**PROPOSED MIXED USE DEVELOPMENT
WOODSTOCK EAST, OXFORDSHIRE
APPLICATION REF. - 14/02004/HYBRID**

TRANSPORT ASSESSMENT APPRAISAL NOTE

This Note has been prepared by Glanville Consultants on behalf of Woodstock Town Council to summarise preliminary findings of a review of the Transport Assessment (TA) prepared by David Tucker Associates (ref. SJT/NES 15291-02j) dated 28 November 2014. The TA accompanies a part outline part full application for mixed use development on approximately 50 hectares of land east of Woodstock, Oxfordshire.

JOB TITLE South East Woodstock		CLIENT Pye Homes	
DRAWING TITLE Marlborough School Coach Park			
SCALE 1/1250@A3	DRAWN BY BP	DATE Sept14	DRAWING No 15291-23
			REVISION

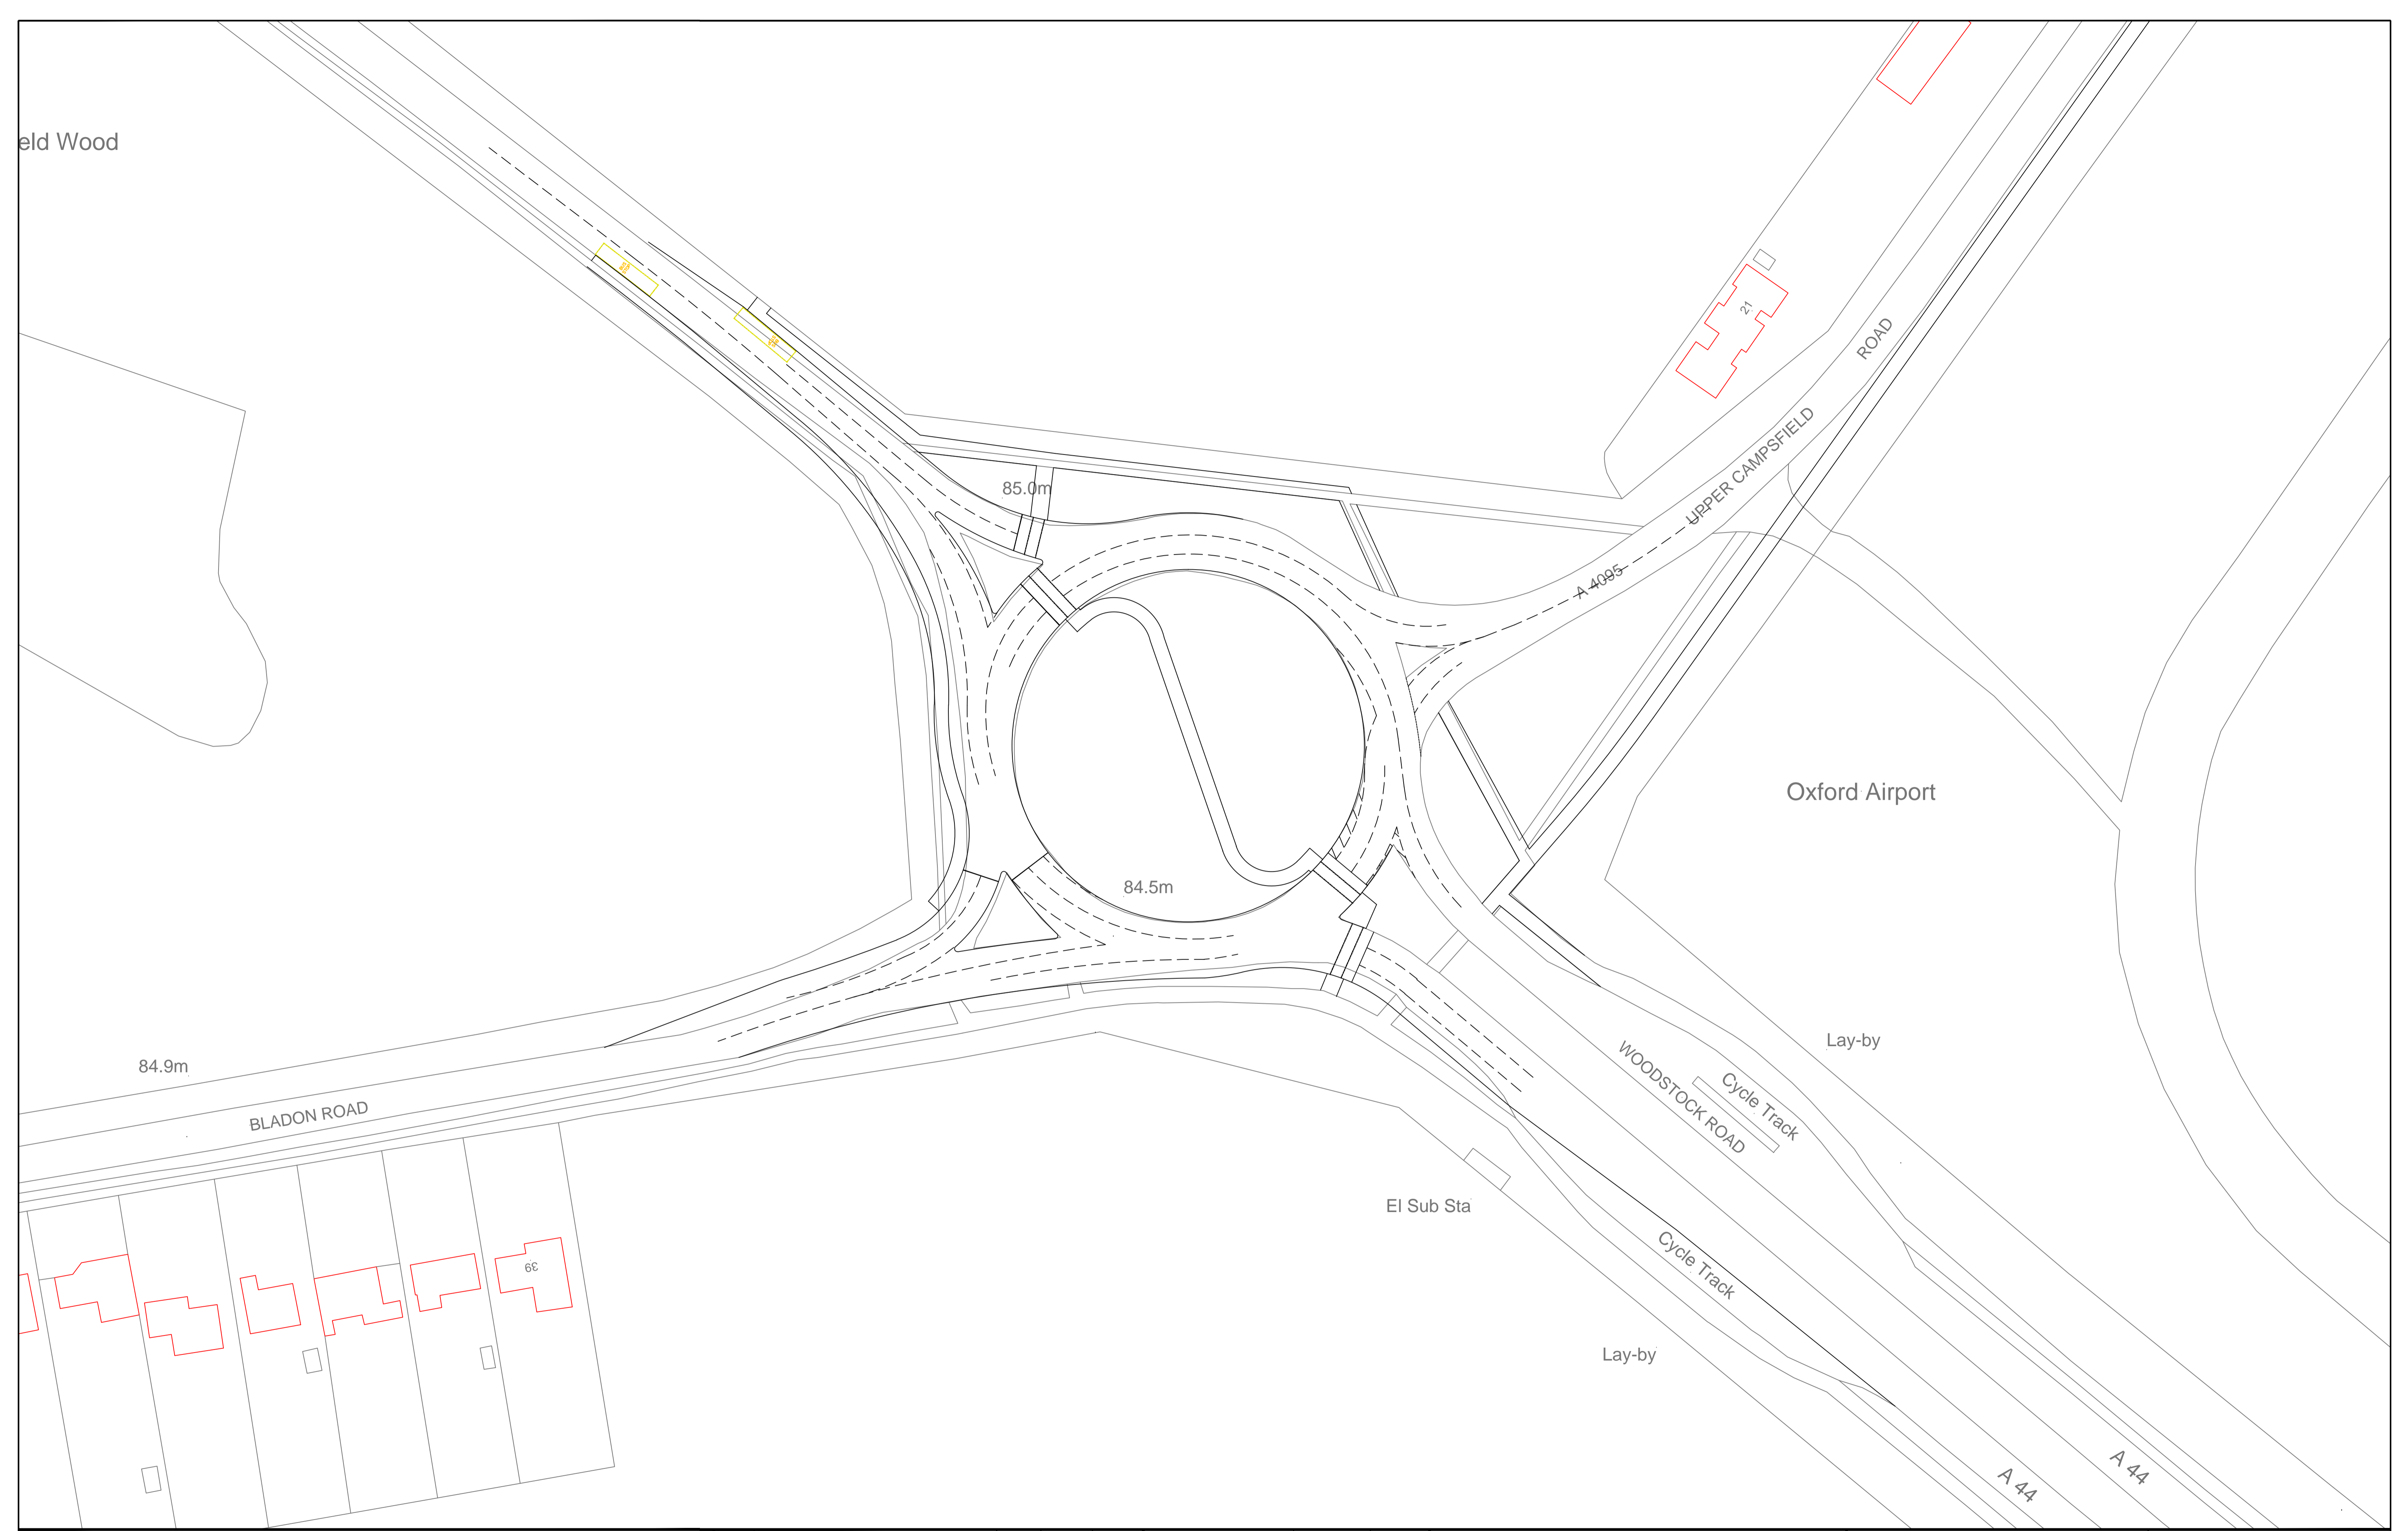
9. The proposed new Marlborough School Coach park and road alignment appears to require third party land and it is not clear whether this is available.
